12287  
21 May 2012

**MODIFICATION TO MAJOR PROJECT MP 06\_0210  
DESIGN AMENDMENTS TO THE BOAT STORE BUILDINGS**

We refer to the abovementioned approved Project Application for the Sydney Boathouse (formally known as the Rozelle Bay Marine Centre) at Lots 29 and 30, James Craig Road, Rozelle.

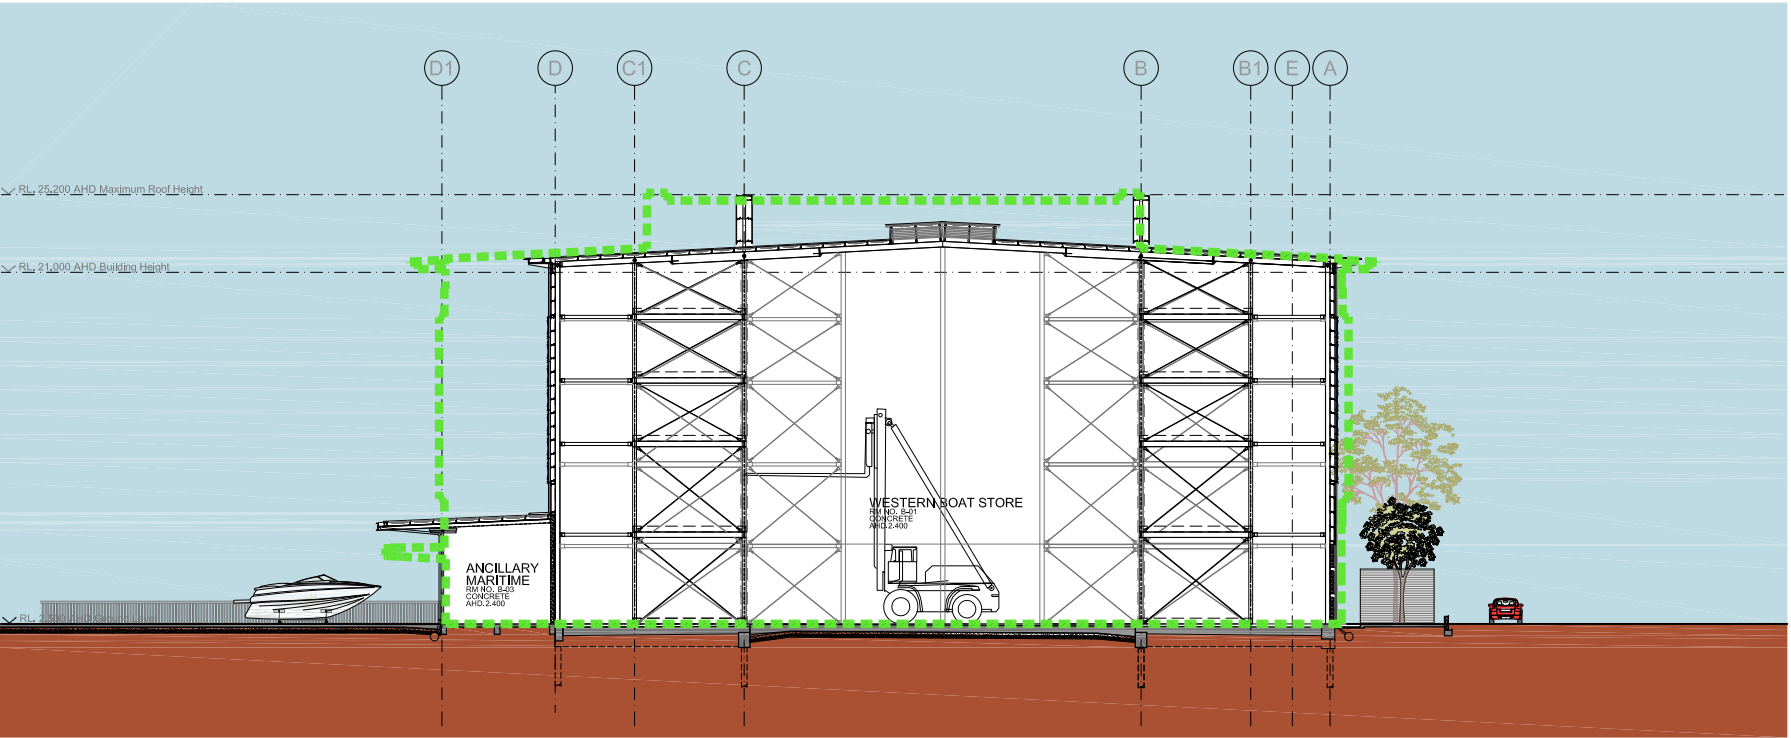
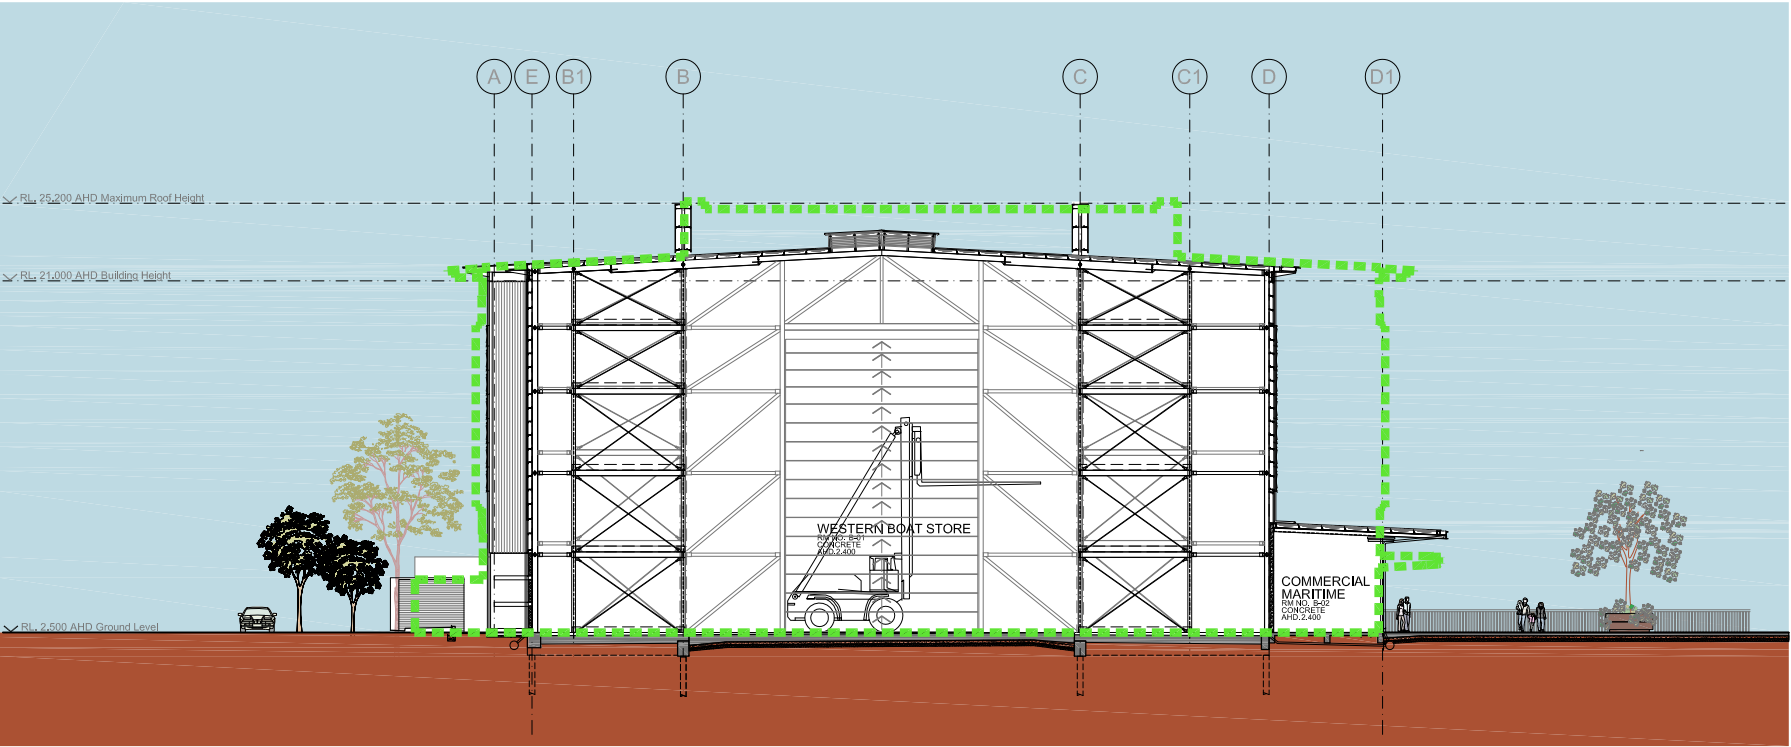
Minor changes are proposed to the design and form of the Western Boat Store as detailed above. The separation of the ancillary marine workshop and retail areas from the boat storage racking results in a stepping of the built form on the building's southern elevation, as illustrated in **Figure 2** below and on drawing B-210-DA included at **Attachment A**.

The proposed amendment results in minor changes to the building footprint and introduces a stepped element due to the separation of the workshop area from the boat racking, which no longer extends out over the marine workshop and retail areas. As the Western Boat Store sits behind the commercial maritime building these changes are visually obscured when viewed from the water. The changes to the roof design to a low pitch roof also reduce the roof profile of the building.

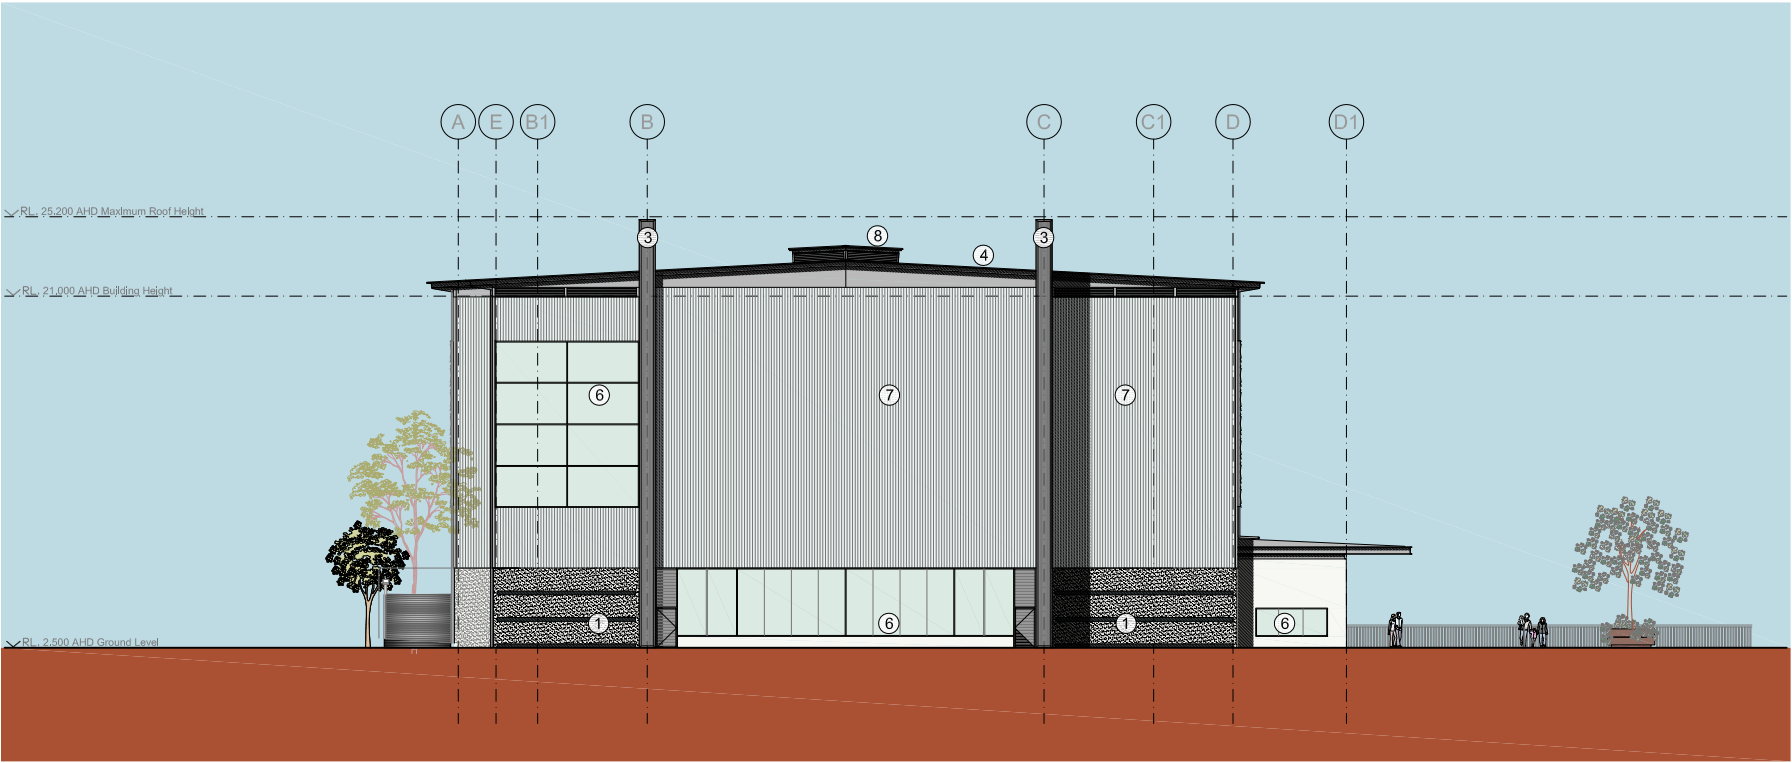
The changes to the external materials and finishes proposed to the Eastern and Western Boat Store buildings are detailed on drawings A-200 and A-201 (Issue G) and B-200 and B-201 (Issue G) at **Attachment A**. The key changes to the materials are:

- A reduction of the extent of the glazed facade at the western end of the northern elevation of the Western Boat Store and replacement with a glass reinforced polyester wall sheet (clear).
- A reduction in the area of the glazed facades on the eastern and western elevations of the Western Boat Store.

- Change from Pre-cast off-form concrete (off-white) (Finish 3) to metal sheeting with Colorbond dark grey finish.
- Change to the colour of Finish 4 from Colorbond Ironstone to Colorbond Coolmax.
- Change of Finish 5 from perforated aluminium sheet metal screens to glass reinforced polyester wall sheet (grey).
- Change of Finish 7 from clear Polycarbonate sheet to glass reinforced polyester wall sheet (clear).
